Re: Porch Plan Review & Structural Specifications

104 Sherman Pines Dr, Fuquay-Varina, NC 27526 - Harnett Co.
Project #: 23091 - Revision 1-7/7/23

TITLE:
**HOBBS COVERED DECK
(OPTION 3)**

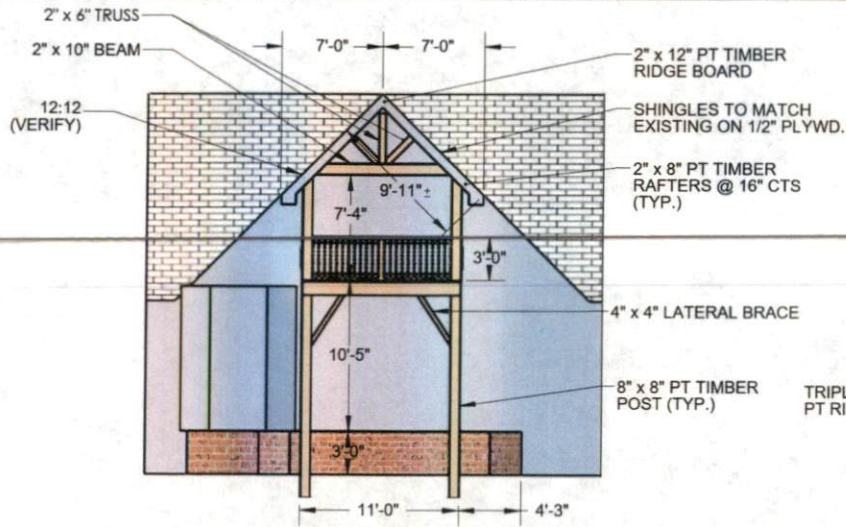
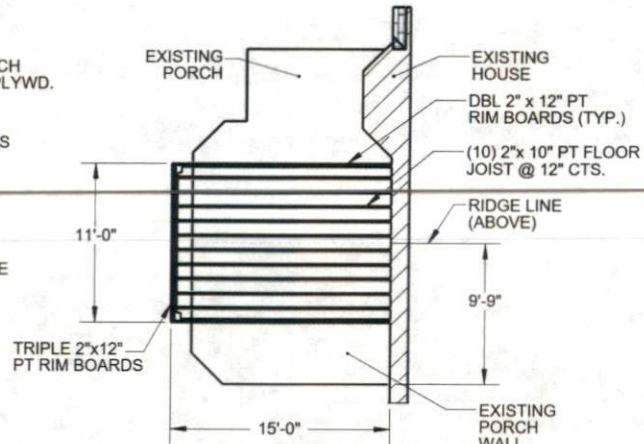
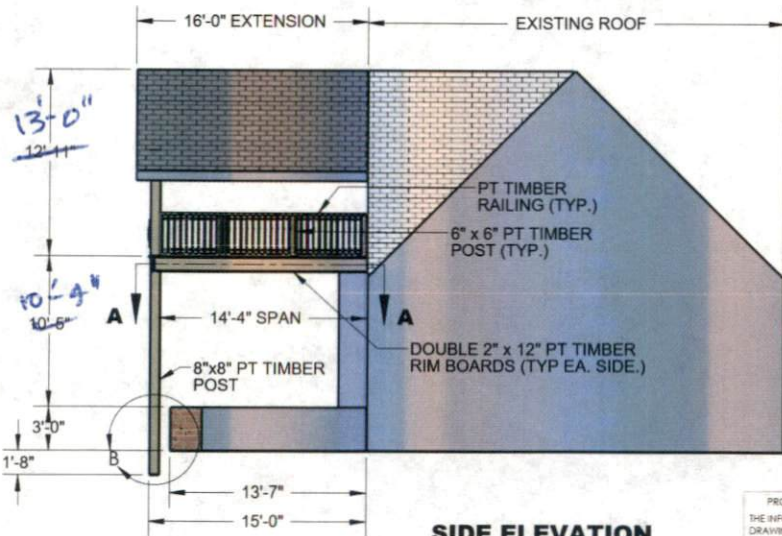
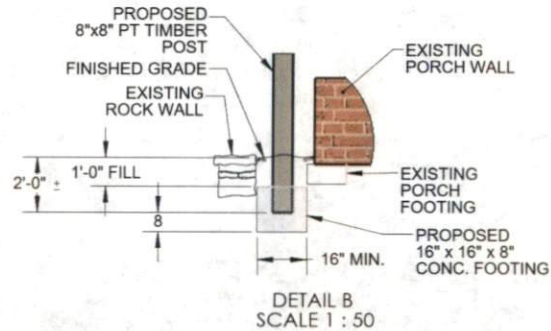
1. The structure being reviewed is a proposed second floor deck and porch addition to an existing home. The porch dimensions are 11'x15' with a cathedral ceiling.

2. Required Roof Framing Specifications:
 - 2x8 Rafters @16" O.C. may be used for the porch rafters.
 - A single ply 1.75"x11.25" LVL ridge beam shall be used to support the rafters.

- Support the interior end of the ridge beam with a 2-ply 2x4 stud column down to the existing exterior stud wall. Support the exterior end of the beam with a 4x4 P.T. post to the porch header below.

- The porch headers along the eave sides of the porch roof shall be a 2-ply 2x10. The porch header at the gable end of the porch shall be a 3-ply 2x10.

- Support the eave roof headers at the existing exterior wall with a 2-ply 2x4 stud column. Support the headers at the exterior edge with 8x8 P.T. posts.

3. Required Deck Floor System Framing:
 - Deck floor joists shall be P.T. 2x10's @12" O.C.
 - Attach a 2x12 ledger board to the existing house using the ledger attachment detail at the end of this report.

- Support the deck joists at the outer edge of the deck with a 3-ply 2x12 P.T. deck band. Joists shall be supported at the deck band by attaching a 2x2 P.T. ledger strip with (3) 16d nails @ 12" O.C. Alternatively, SST LUS210Z face mount joist hangers (or equivalent product) may be used in lieu of the ledger strip.

- 8x8 P.T. support posts shall have "Y" bracing attached at each corner parallel with the rear wall of the house. Refer to the "Y" bracing detail attached at the end of this report.
